**From:** Martyn White <Martyn.White@arun.gov.uk>  
**Sent:** 18 November 2019 14:54  
**To:** Planning.Responses <Planning.Responses@arun.gov.uk>  
**Subject:** AB/102/19/HH

### **AB/102/19/HH**

The proposal is for a replacement summer house which is located in the rear garden area. It is noted from the Design & Access and Heritage Statement that, whilst in the same location, the new structure is to be smaller than the existing one.

SUN LOUNGE DIMENSIONS
ALL DIMENSIONS APPROXIMATE

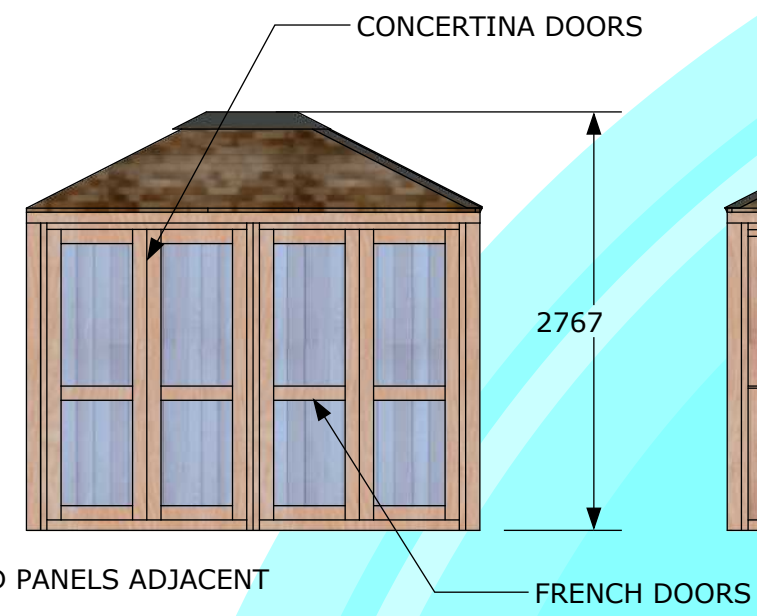
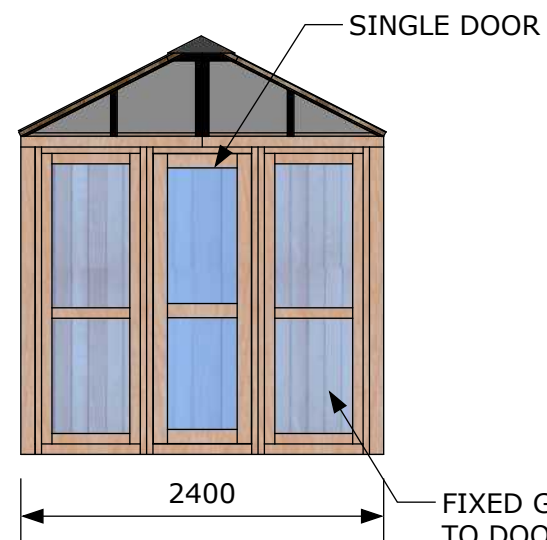
Whilst the plans indicate that the summerhouse is more modern in terms of its appearance, this is not considered to detract from the character of the area or the setting of the listed building.

Likewise, the materials proposed for the structure are considered to be acceptable; it is assumed that the intention is to let the wood weather down to a natural finish so that it has a soft grey appearance. Is this correct?

However, it is thought that the rainwater goods could be provided in a more appropriate material (such as aluminium) so that it is reflective of the various heritage assets in the local area.
